Ref planning application 2020/91601

Please find attached some general comments relating to the proposed change of use and extension of the Dunkirk pub at 231 Barnsley Road. We are generally supportive of the development but would object if certain restrictions could not be put in place.

Proposed Ground Floor Layout
1:100

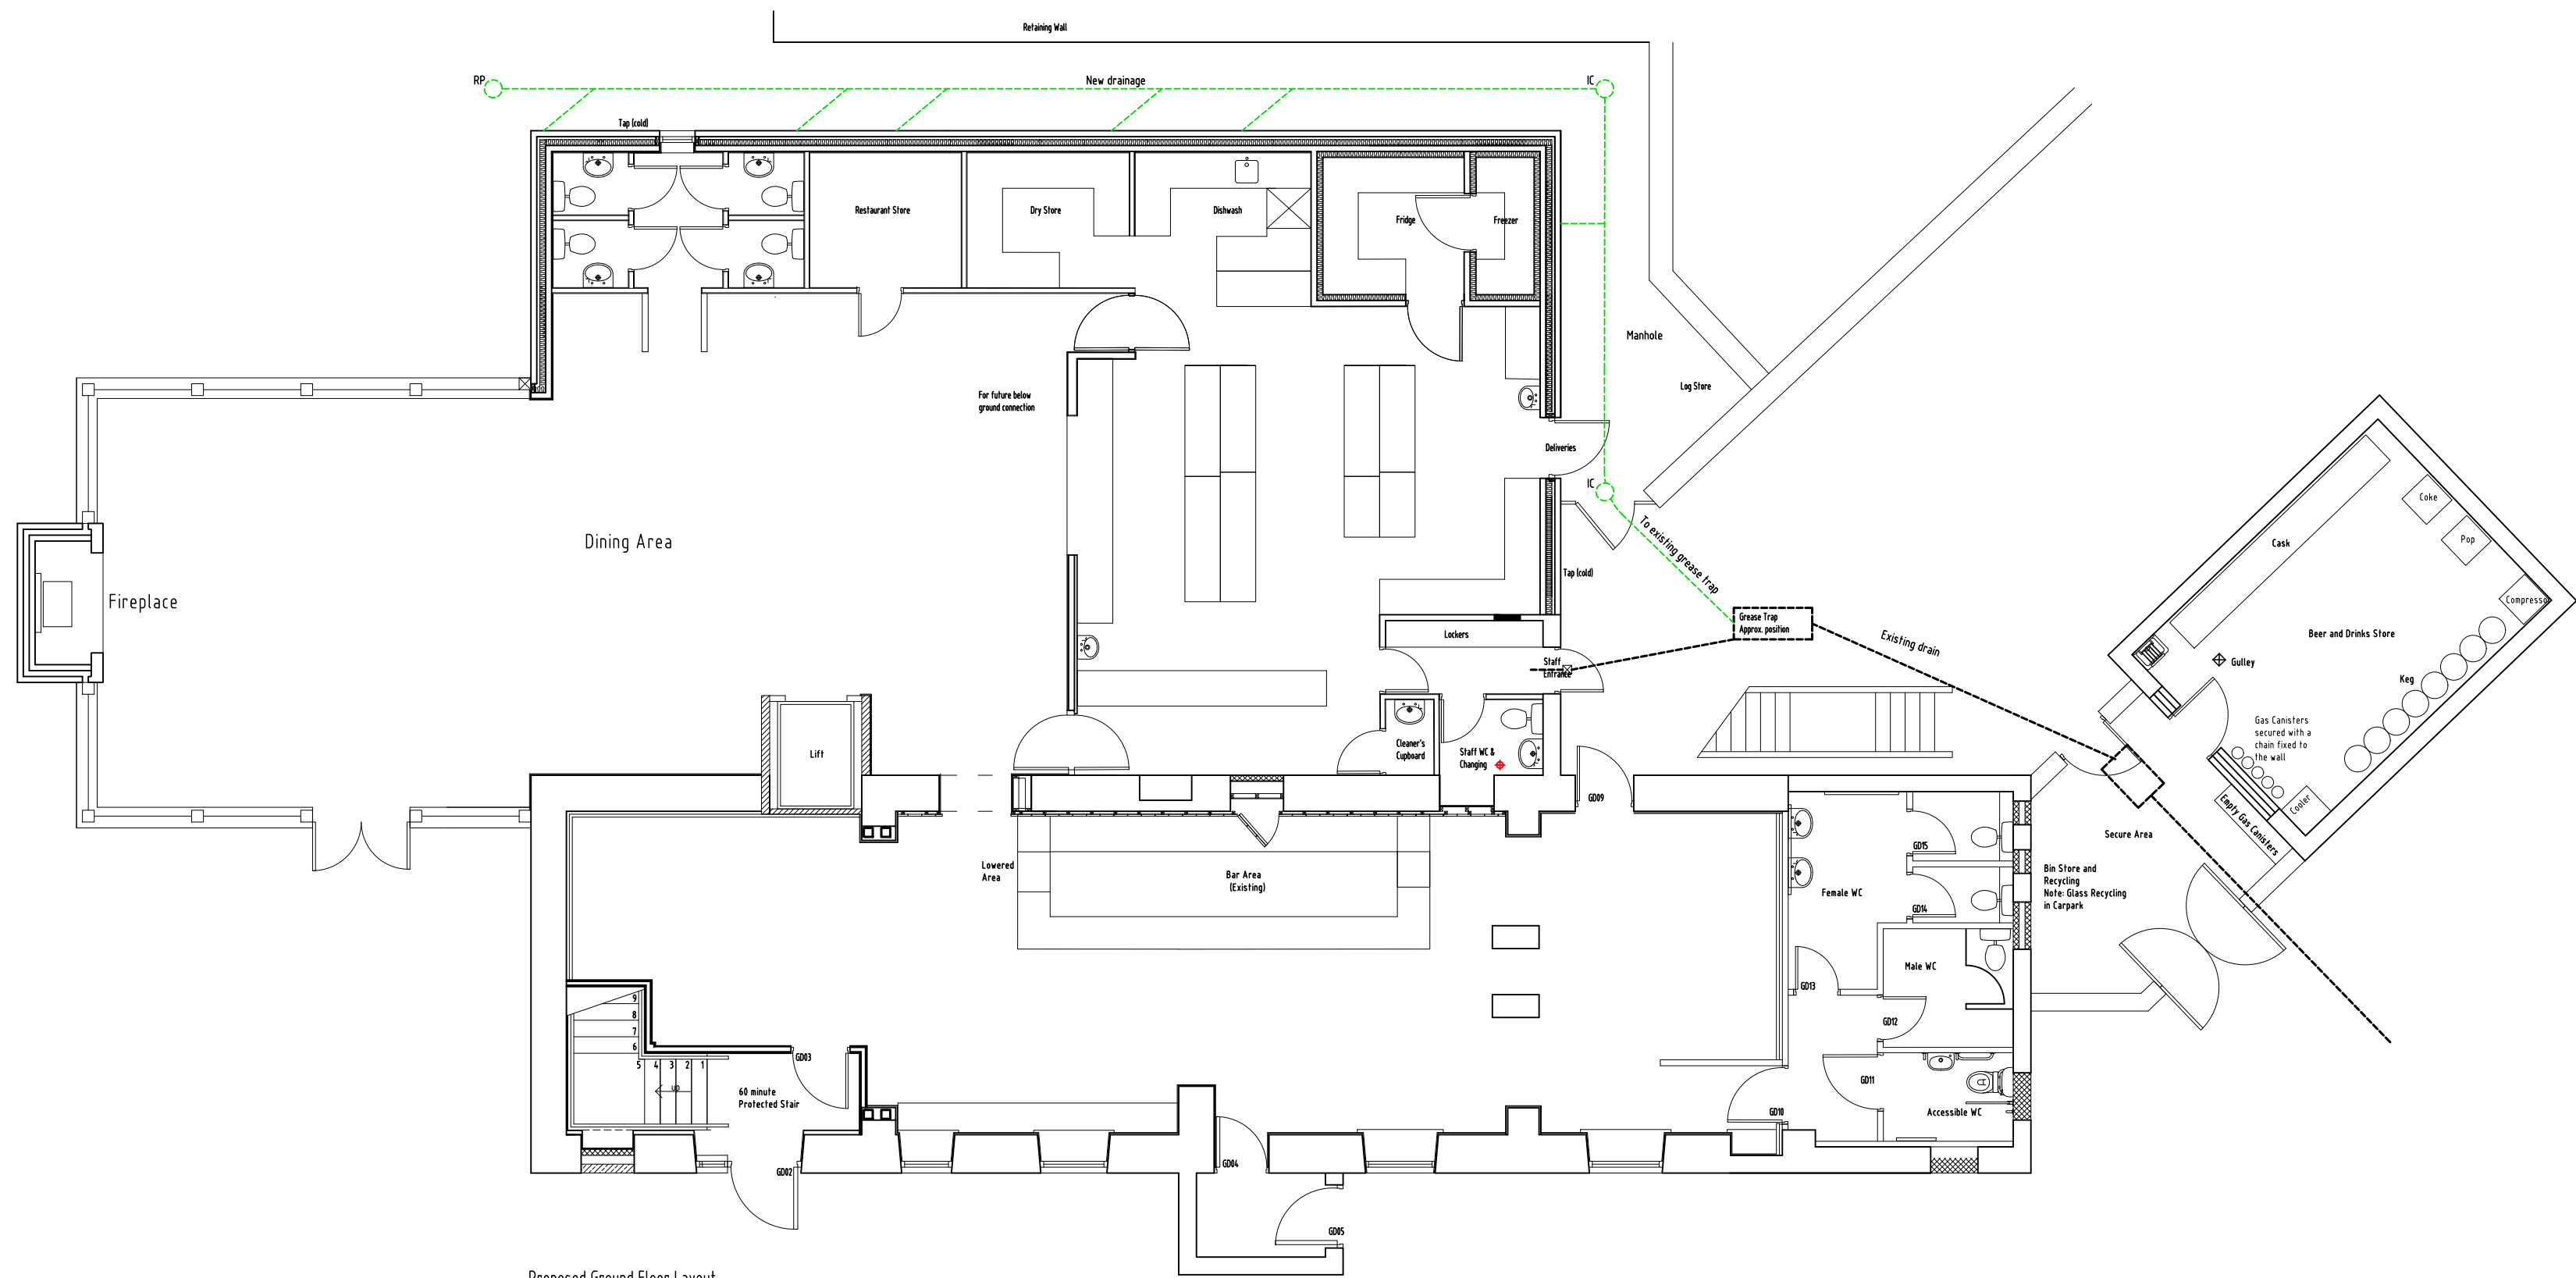
Provision for additional and adequate extraction should be made given the positioning of the new proposed kitchen area and its increased proximity to neighbouring properties.

Proposed Block Plan
1:200

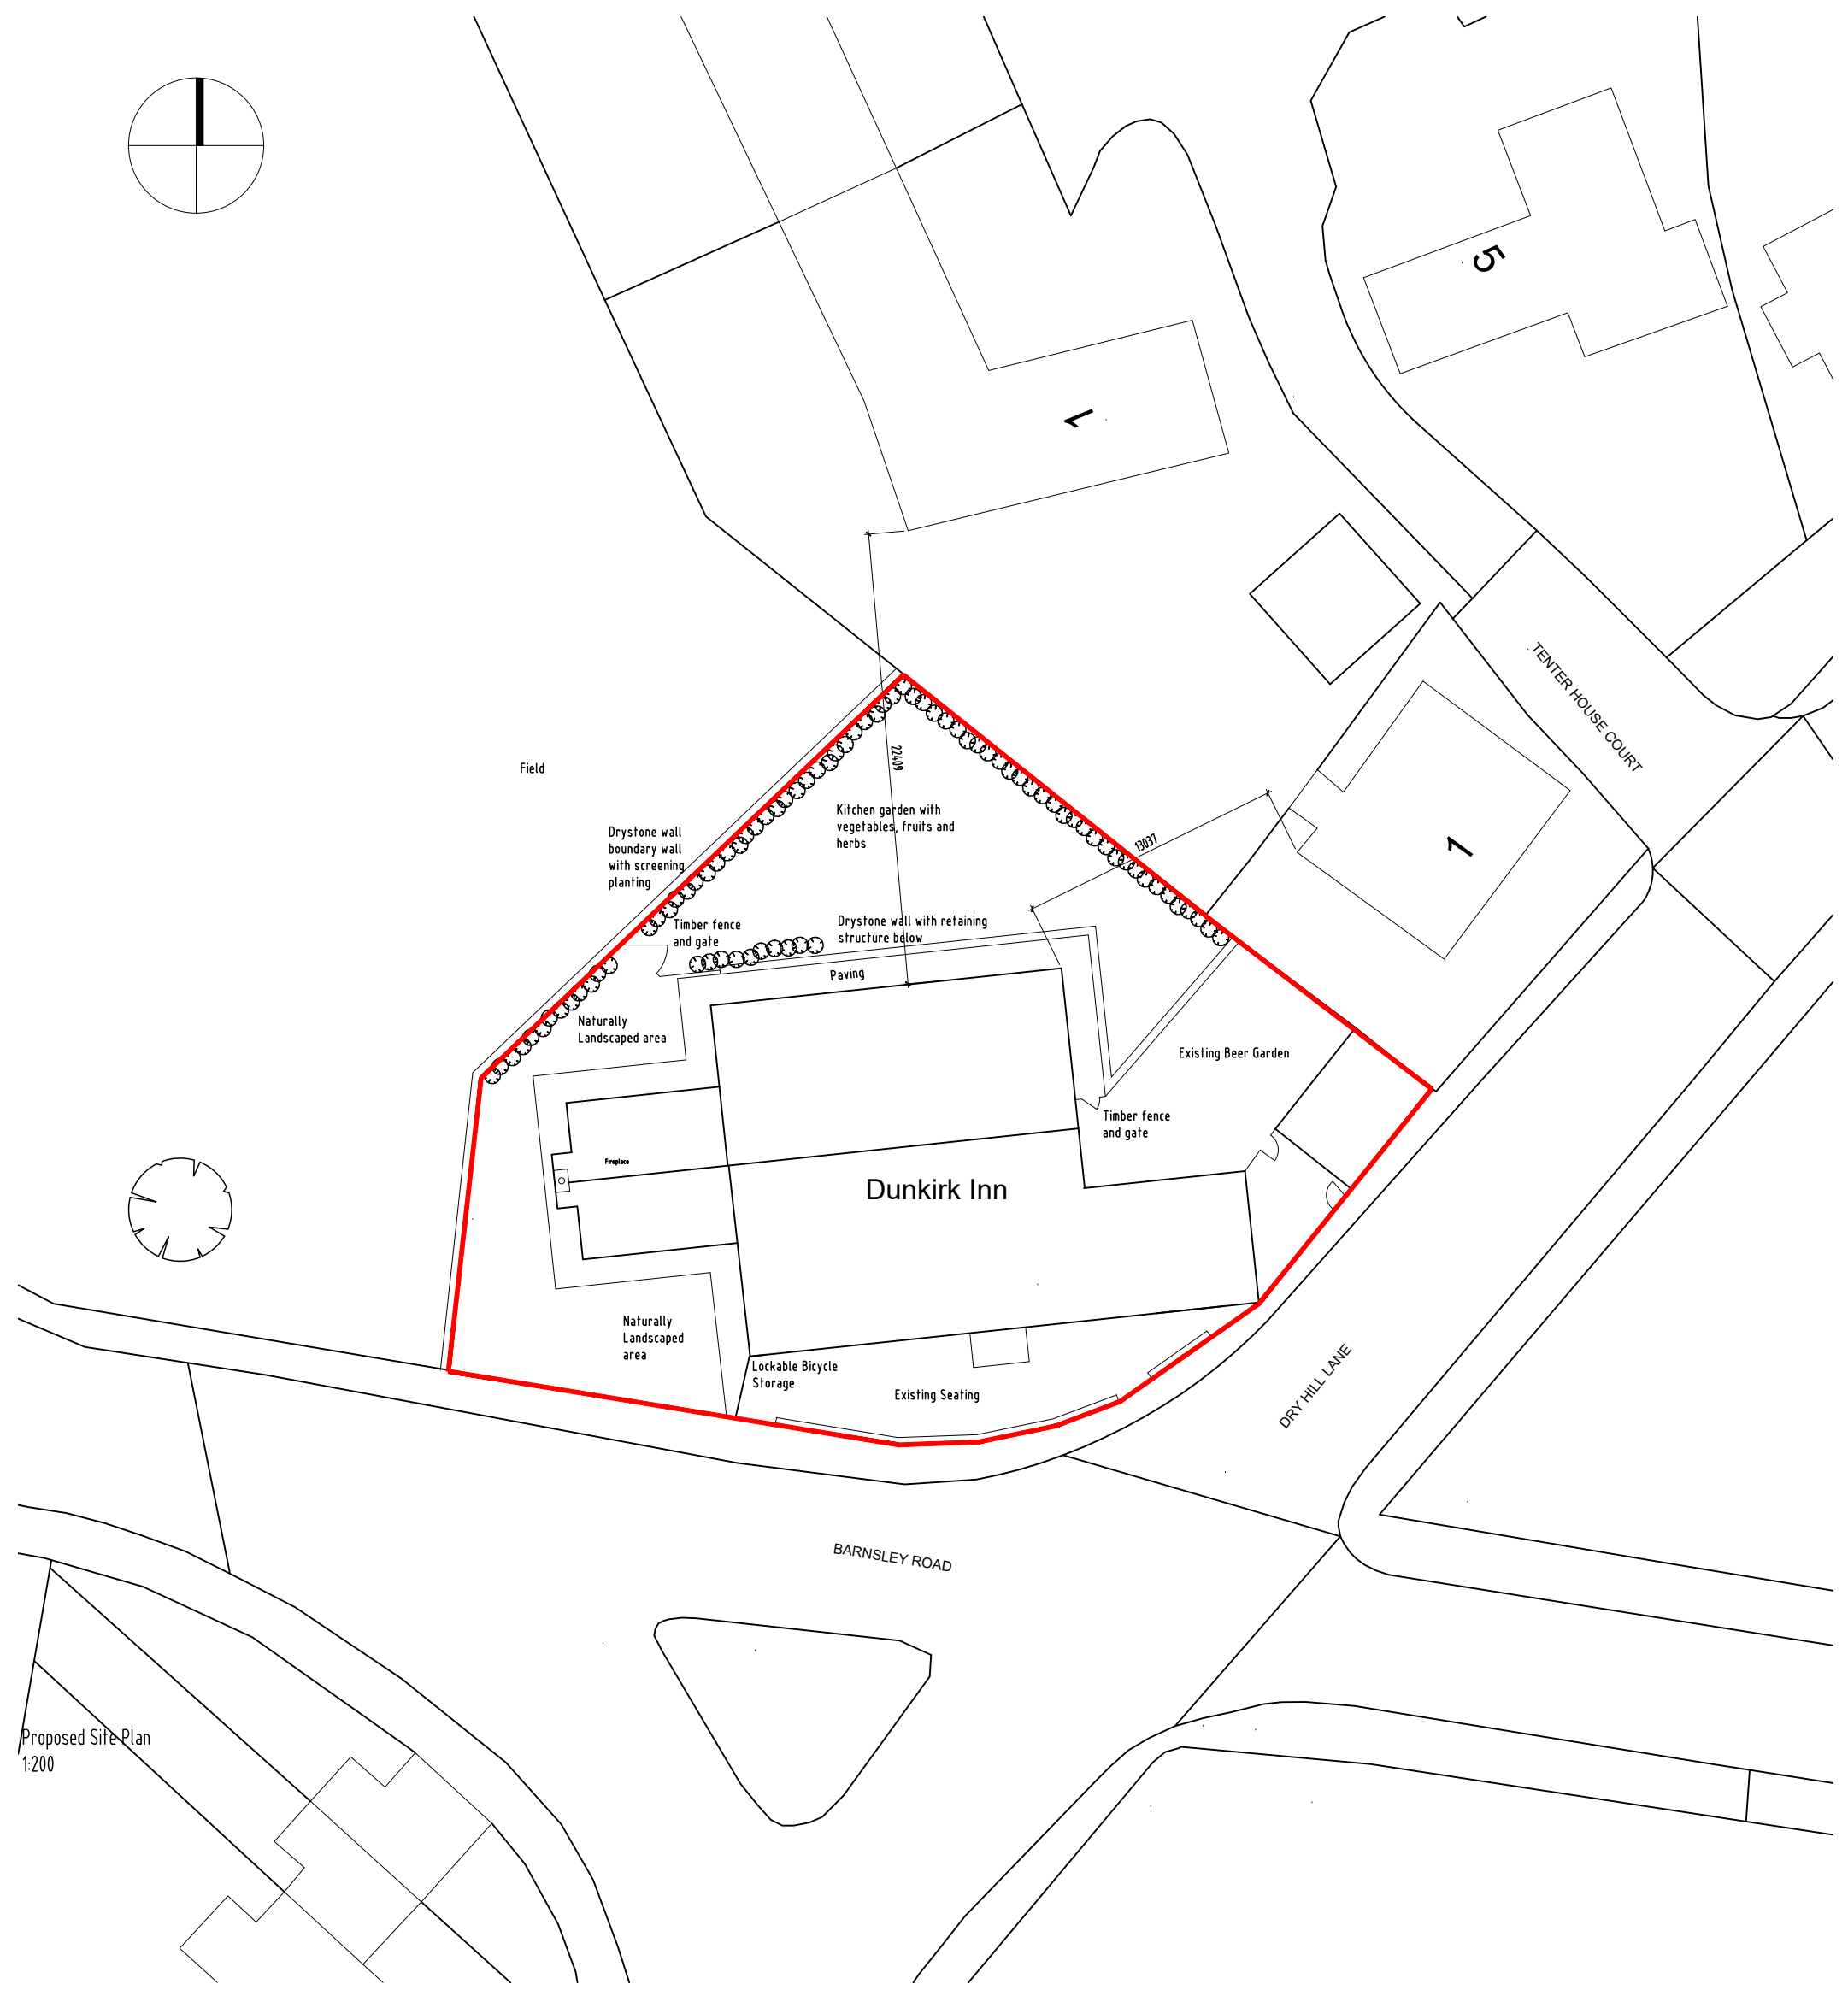
It is not clear on the plan (red lined area) exactly what the demarcation is for the area that is defined as a public outdoor space and which area is defined as the small kitchen garden (which will only be maintained by staff). It should be clarified on any plans accepted that the extent of the existing outdoor public spaces in order that absolute certainty is achieved for current and future owners of the pub and also for the neighbouring properties. There should be specific provision that prohibits the general public from used areas not currently used as outdoor public spaces, and this should be clearly demarcated on final plans. It is not acceptable for either the pub or the neighbours to rely on the phrase “no significant alterations”.

Foundations have started to be laid for what is described as a cold storage unit in the small garden area (approximately as per the attached image – brown rectangle). This new outhouse is closely proximate to the boundary of properties on Miller Hill and Tenter House Court. This is not on the plans that have been uploaded to the planning portal and it is important that the construction of this outhouse should also be in keeping with the construction of the pub as well as the neighbouring properties, one of which is a listed building

The main drainage for the properties at Tenter House Court runs through the area that is marked for the small garden area in the Dunkirk and may run underneath the proposed kitchen extension in part. The drainage must be adequate for the increased usage as a result of additional customers. It must also be stipulated that in the case of failure of the drainage systems that the relevant water authorities and the residents of Tenter House Court have adequate access in order to resolve issues.
